Our ref: The Gunlake Quarry Continuation Project (SSD-12469087)

**Subject:** Request for Additional Information

I refer to the assessment for the Gunlake Quarry Continuation Project (SSD 12469087) (the project) and request additional information on the water management strategy presented in the project's *Environmental Impact Statement* (EIS).

Figure 5.1 Surface water management strategy (RHDHV 2016)

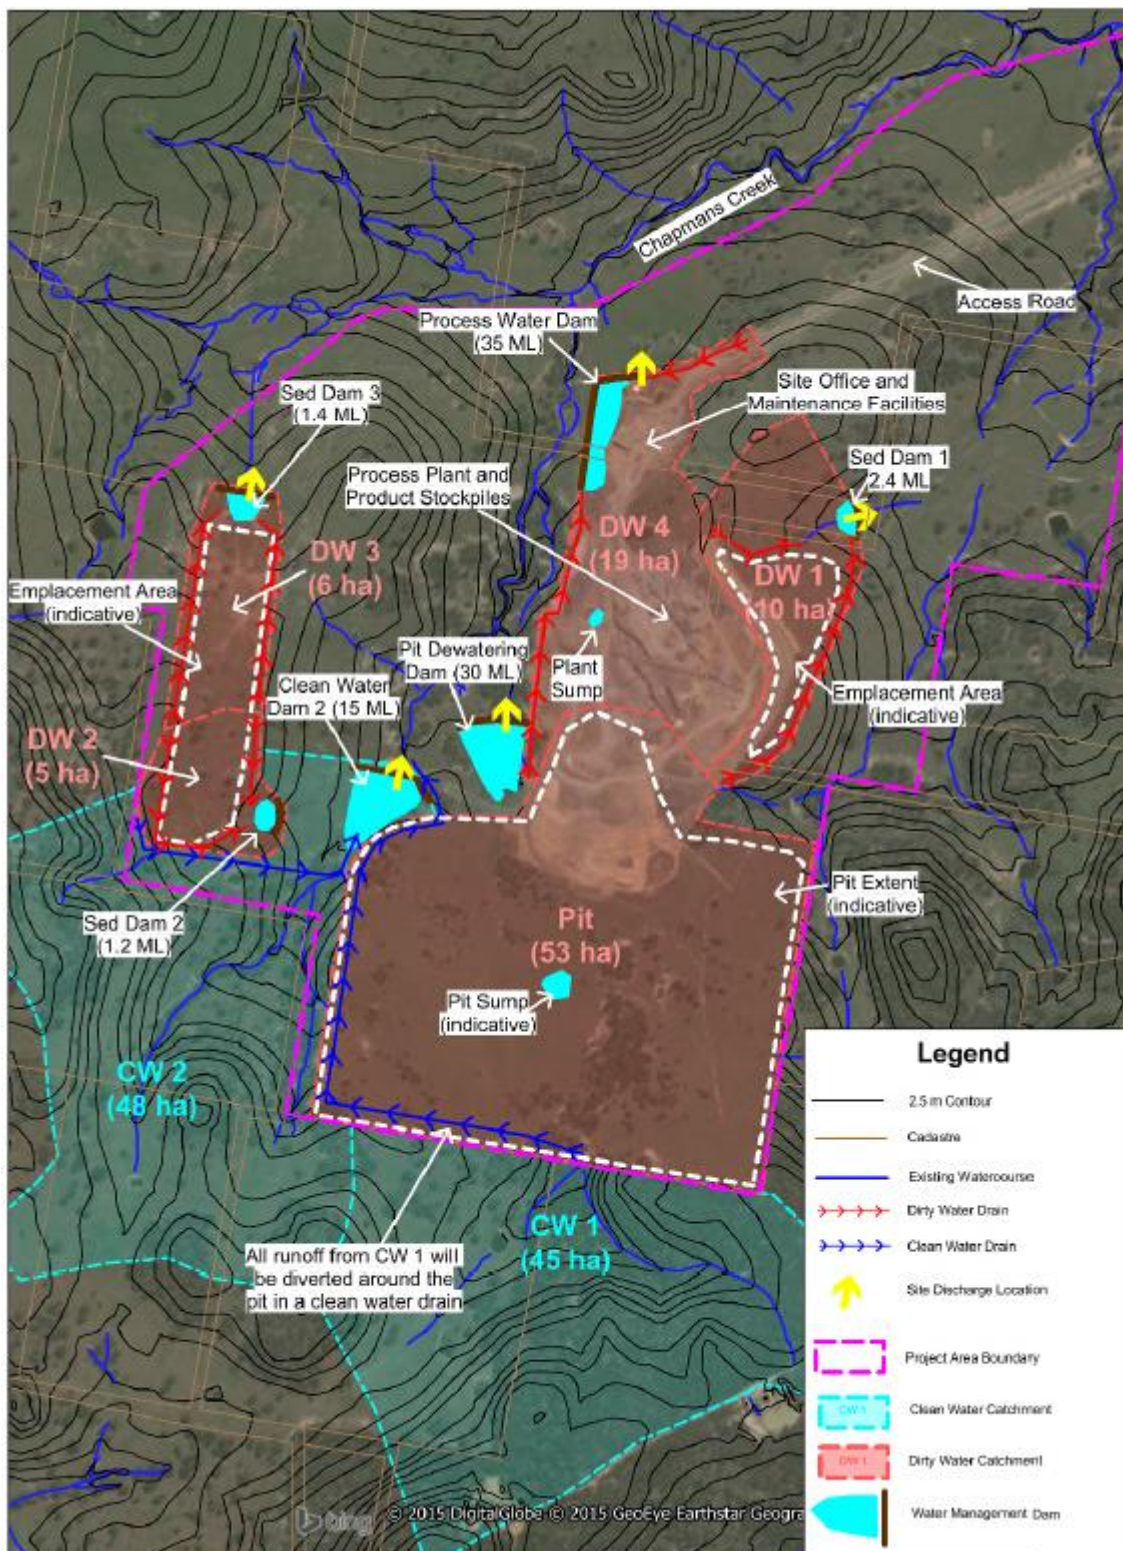
I note that Figure 5.1 in the Surface Water Assessment (Appendix F.6) of the EIS has used 2015 aerial imagery as base map for the water management strategy at the site which may not reflect accurate delineations of clean / dirty water catchments or the locations of the clean/dirty water diversion drains. Other plans in the EIS, which use the more recent 2021 aerial imagery, show that there have been significant changes to the site topography and an increase in disturbance areas between 2015 and 2021 due to quarry operations.

- an updated water management strategy plan that uses a more recent aerial imagery as base map to reflect accurately the site's existing topography
- locations on the updated water management strategy plan of the:
  - ¾ key existing and proposed water management infrastructure (dams, diversion drains for clean and dirty separation), including the onsite effluent system (septic tank and the absorption trench system area)
  - ¾ approved eastern and western emplacement areas, the quarry pit area and the process plant and stockpile areas

¾ storage location and stockpile area for the proposed receipt and management of 50,000 tonnes/year of cured concrete waste
